**KIRKLEES METROPOLITAN COUNCIL
INVESTMENT & REGENERATION SERVICE**

DELEGATED DECISION TO DETERMINE PLANNING APPLICATIONS

Reference No:	2022/62/91188/W
Site Address:	100, St John's Road, Birkby, Huddersfield, HD1 5EY
Description:	Erection of single and two storey side and two storey rear extensions to increase ground floor retail unit and HMO above (within a Conservation Area)
Recommending Officer:	Katie Chew

DECISION - Refuse

WEST ELEVATION

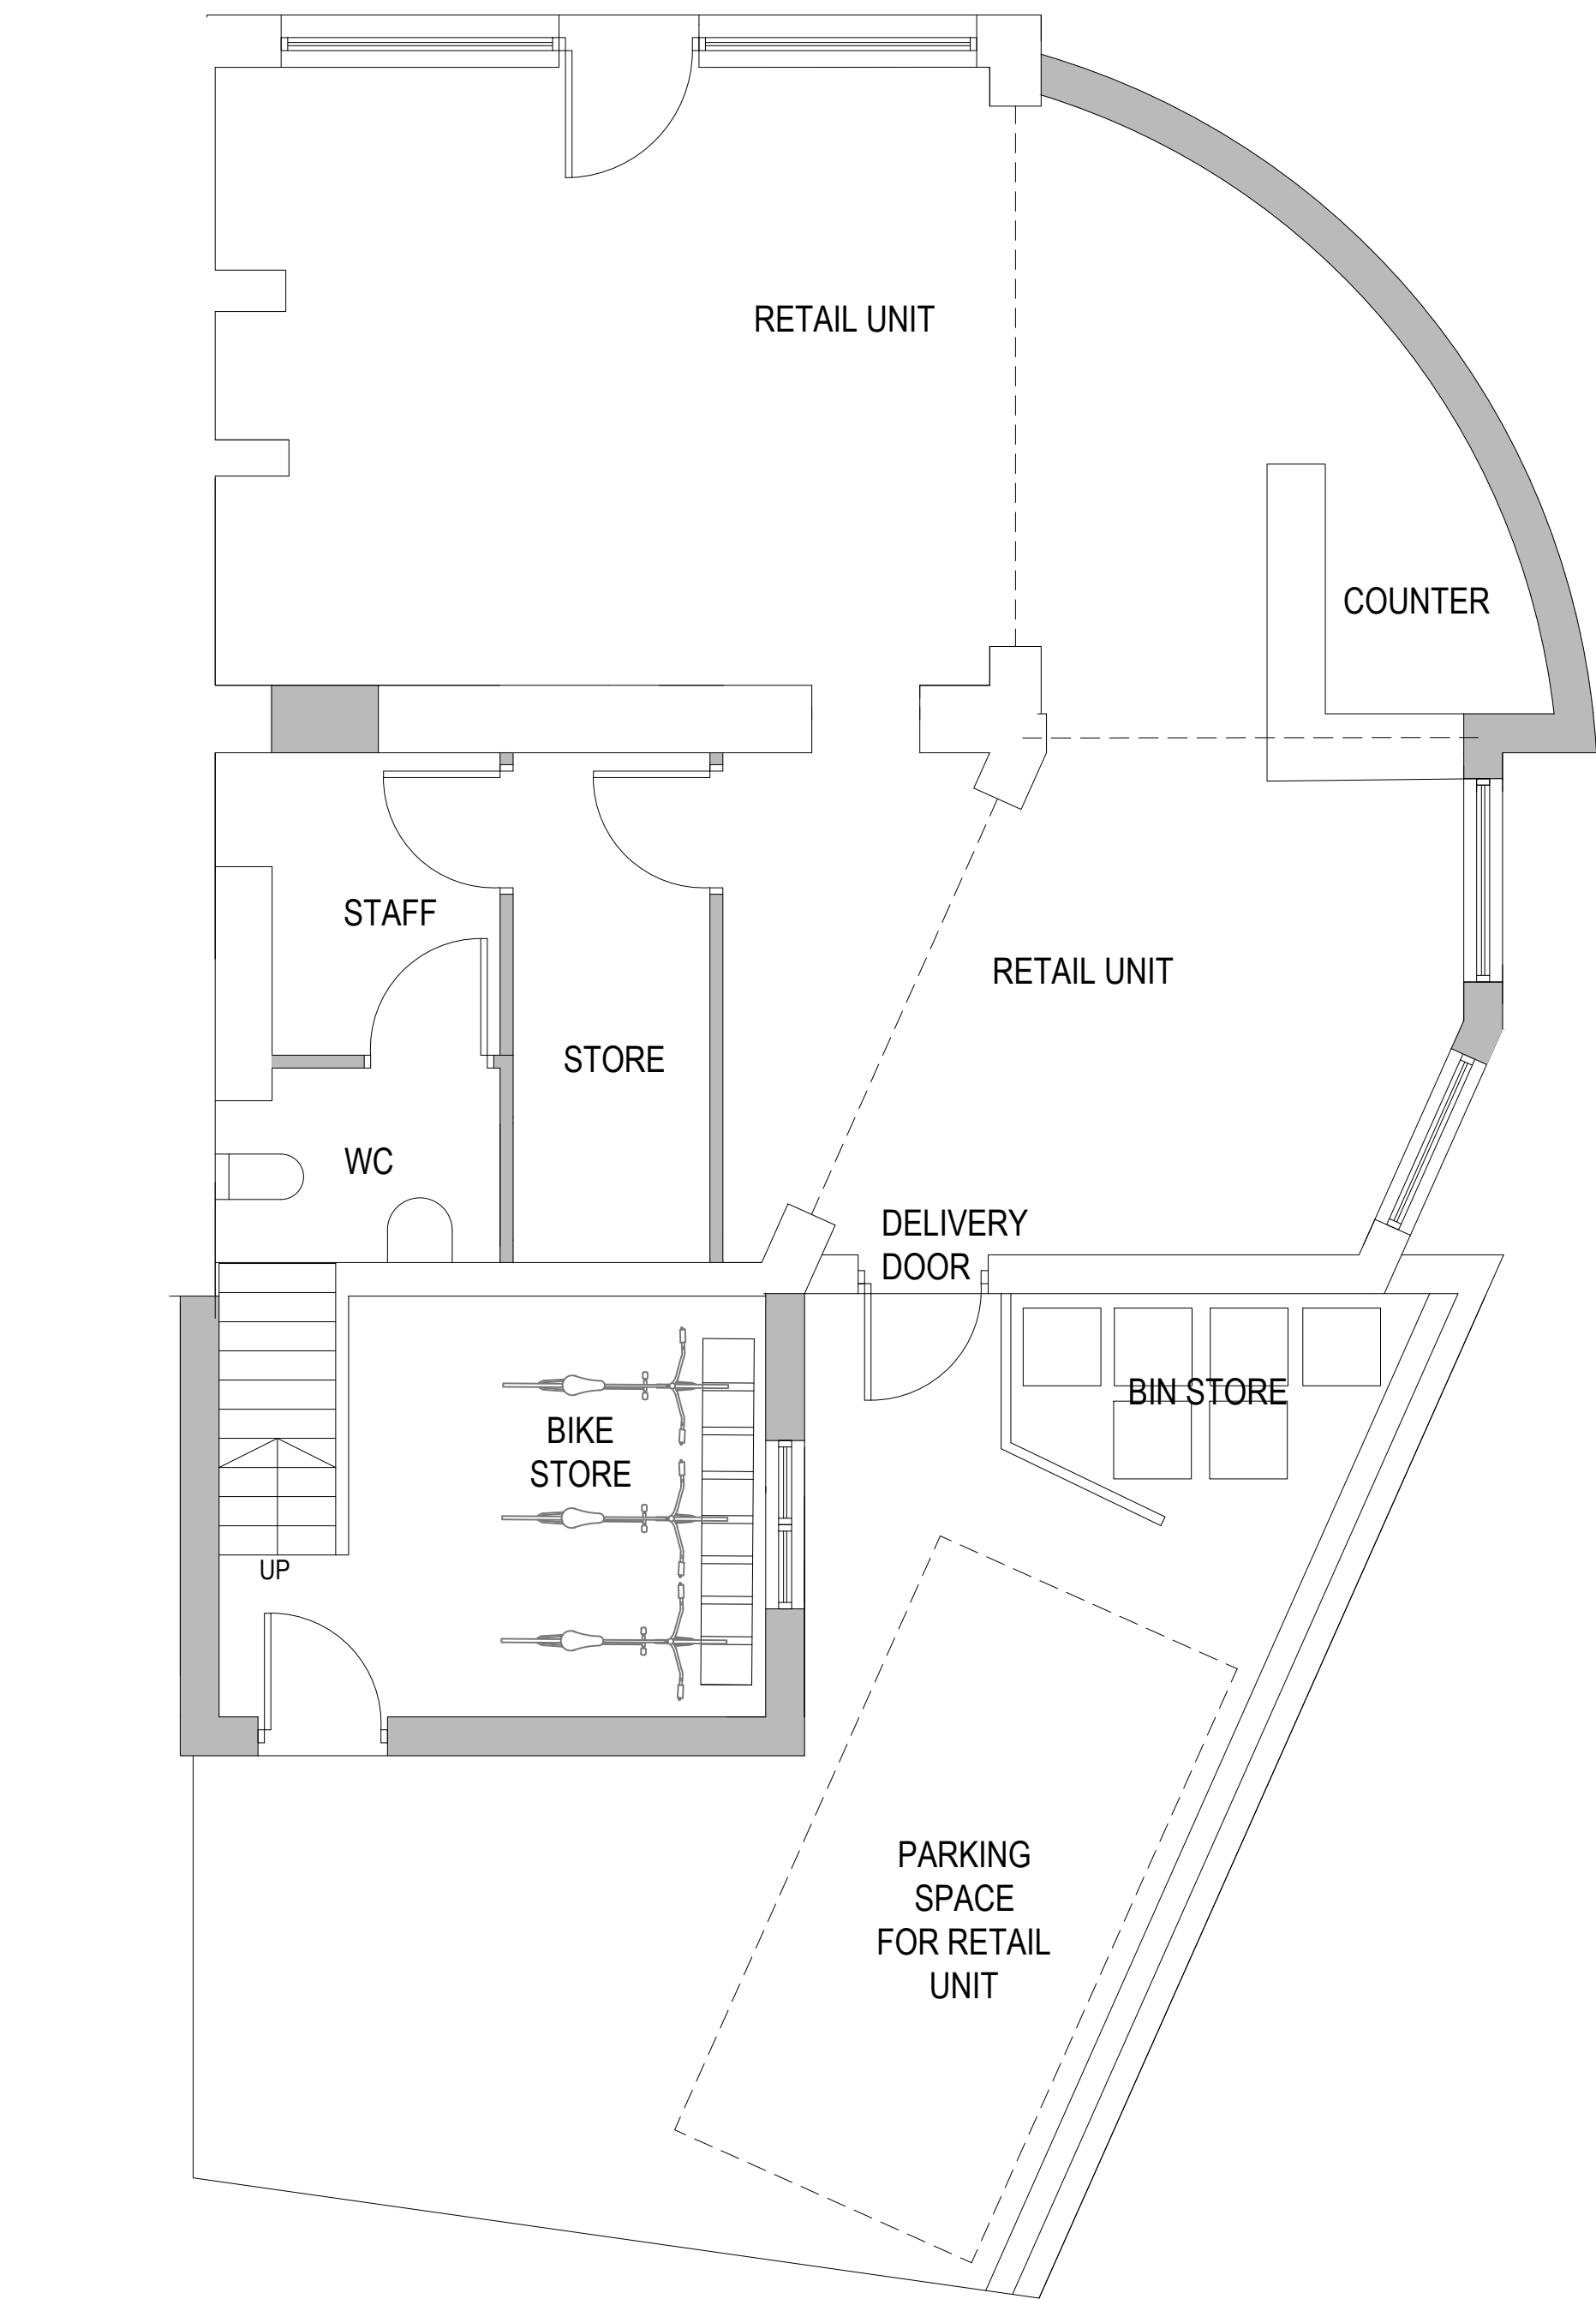
In this instance the proposals seek to build out up to the western boundary, leaving minimal/no space between the extensions and the public highway, and only a limited amount of amenity space would be retained to the area. The side extensions, due to their scale and siting close to the highway of Blacker Road would be dominant and oppressive features from within the highway. Of note, other properties to the north east on Blacker Road are slightly set back from the highway boundary.

In addition, there would be a mixture of roof types including a pitched roof and a flat roof, with a mix of designs which include a curved single storey extension with stone parapet, and this would complicate the form and appearance of the building. This is considered to be incongruous in this location and detract from the host property, which is somewhat traditional in design.

For the above reasons, the proposal is not considered to represent a subservient addition and would result in a visually jarring overdevelopment of the site.

The Conservation Officer does not support the proposals, which would see substantial development (as outlined above) which would also see the loss of historic signage to the rear elevation, which as noted is a key part of the character of the building and area, a rare surviving example in the area. The development while making use of the similar materials does not consider the overall impacts to a key corner plot location. The proposal is considered to cause less than substantial harm to the significance of the Conservation Area. There is no convincing or compelling justification for the proposed works which would have a negative impact to the character of the building and Conservation Area with the noted loss of the historic possibly late 19th early 20th Century signage, which has a strong contributing factor of the building.

For the reasons outlined above, the proposed extensions, by reason of their siting, scale, massing, form and design would fail to represent a subservient addition to the host property and would fail to be in keeping with its scale and detailing. The proposals would introduce an unsympathetic, incongruous and dominant form of development within the Birkby Conservation Area. The proposed alterations would also lead to the loss of historic signage which is deemed to play a key part of the character of this building, with no convincing justification provided for the proposed works. The proposals are therefore considered to harm the visual amenity of the area and cause less than substantial harm to the significance of Birkby Conservation Area. There are considered to be no public benefits that outweigh such harm. The proposal would therefore be contrary to Policies LP1, LP2, LP24 and LP35 of the Kirklees Local Plan, Chapters 12 and 16 of the National Planning Policy Framework, Policy 72 of the Planning (Listed Building and Conservation Areas) Act and Principles 2 and 15 of the Council's adopted Housebuilders Design Guide SPD.

1. The proposed extensions, by virtue of their overall massing and scale, form and design would fail to represent a subservient addition to the host property or be in keeping with the host building in terms of its form, scale and design. The proposal would introduce an unsympathetic, incongruous, complicated and dominant form of development, in a prominent location within Birkby Conservation Area. In addition, the proposal, in relation to the plot size and taking into account its relationship with surrounding development, would represent a cramped form of development constituting an overdevelopment of the site. Further to this, the proposal would see the loss of historic signage to the rear elevation, which makes a positive contribution to the significance of the Birkby Conservation Area. The proposal would therefore cause detrimental harm to the visual amenities of the locality and less than substantial harm to the significance of the Birkby Conservation Area. There are no public benefits which outweigh the less than substantial harm identified to the Birkby Conservation Area. The proposal is therefore contrary to Policies LP1, LP2, LP24, and LP35 of the Kirklees Local Plan, Policy 72 of the Planning (Listed Building and Conservation Areas) Act 1990, Key Design Principles 2 and 16 of the Council's adopted Housebuilders Design Guide SPD and Chapters 12 and 16 of the National Planning Policy Framework.

GROUND FLOOR PLAN

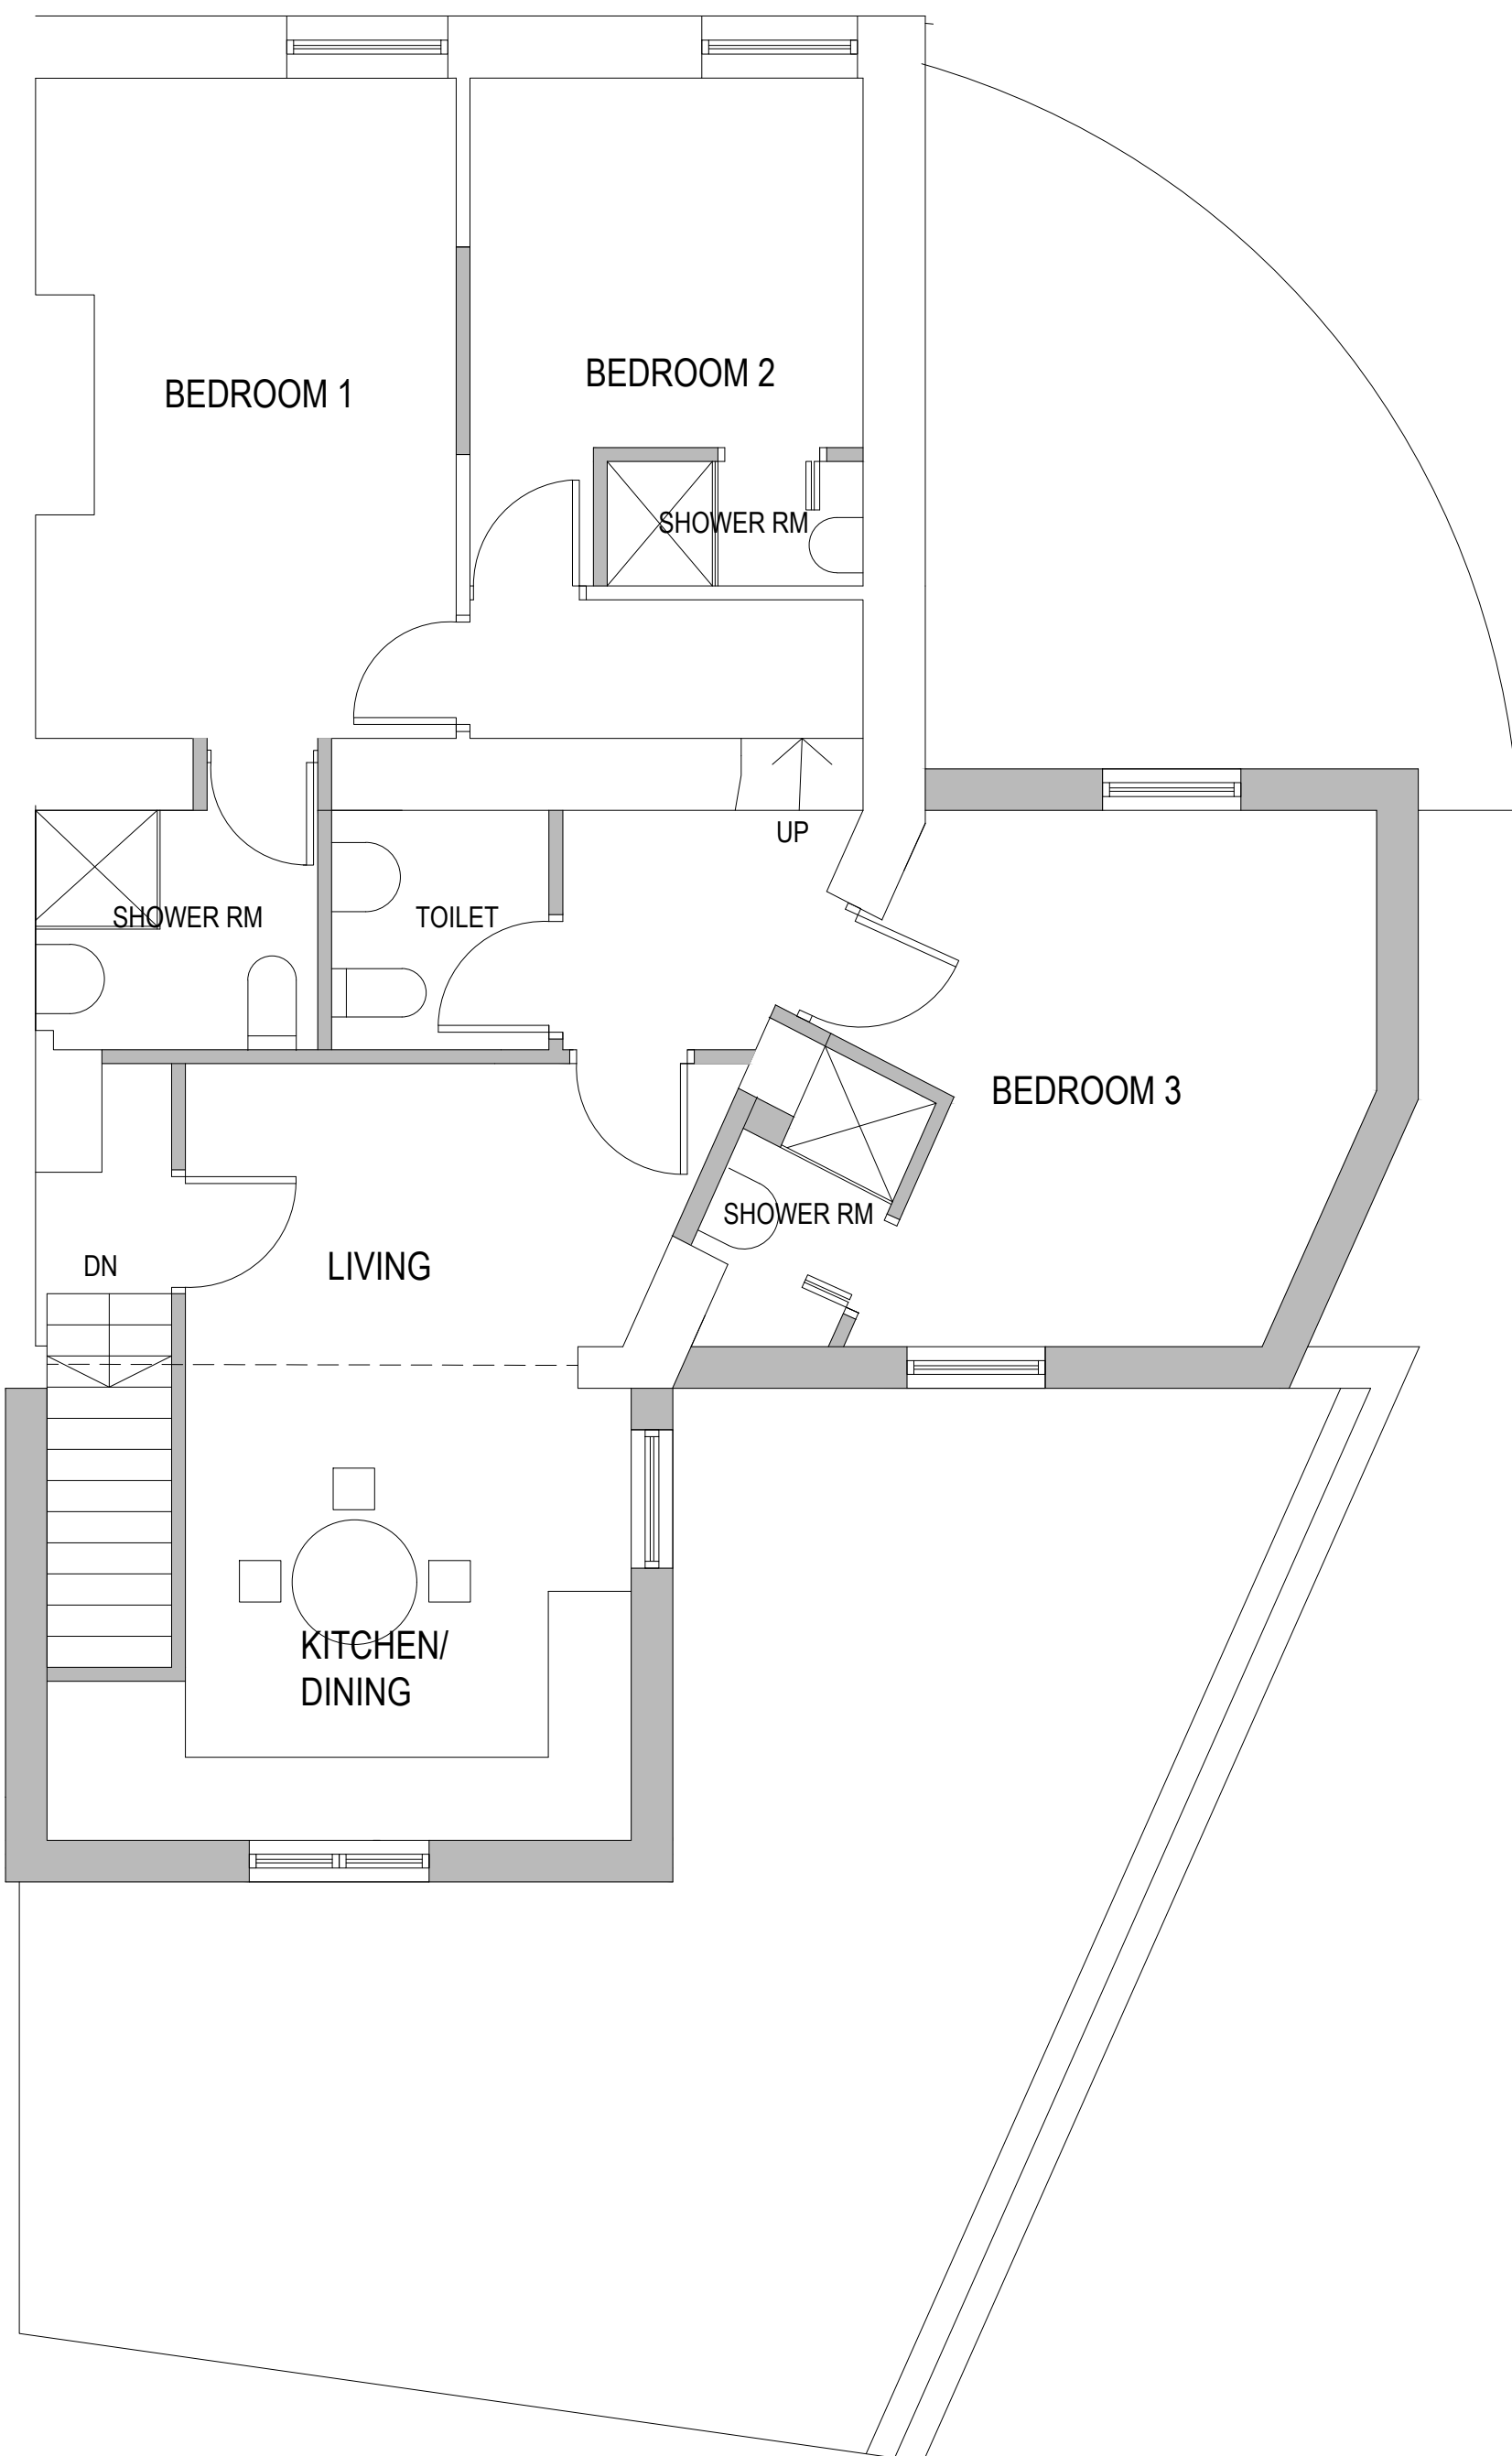
Within the Nationally Described Space Standards it is outlined that a 3 bedroomed single storey dwelling should provide a minimum gross internal floorspace of 74sqm. This would be for 2 single bedrooms and 1 double bedroom. For 3 double bedrooms the minimum gross internal floorspace should be at least 95sqm. The proposed dwelling measures around 82sqm and therefore would be suitable for 2 single and 1 double bedrooms. It is also

A bin store is shown on the submitted plans to the rear of the site. Highways officers raise concerns with this proposed location as it would be set behind the proposed parking area and so would not be accessible for a collection crew. Highway officers would therefore like to see a collection presentation

point marked clearly on a drawing in an accessible place which would not obstruct the access to the parking/delivery space or the highways/footways for road safety reasons. Should planning permission be granted, this could be secured via a condition.
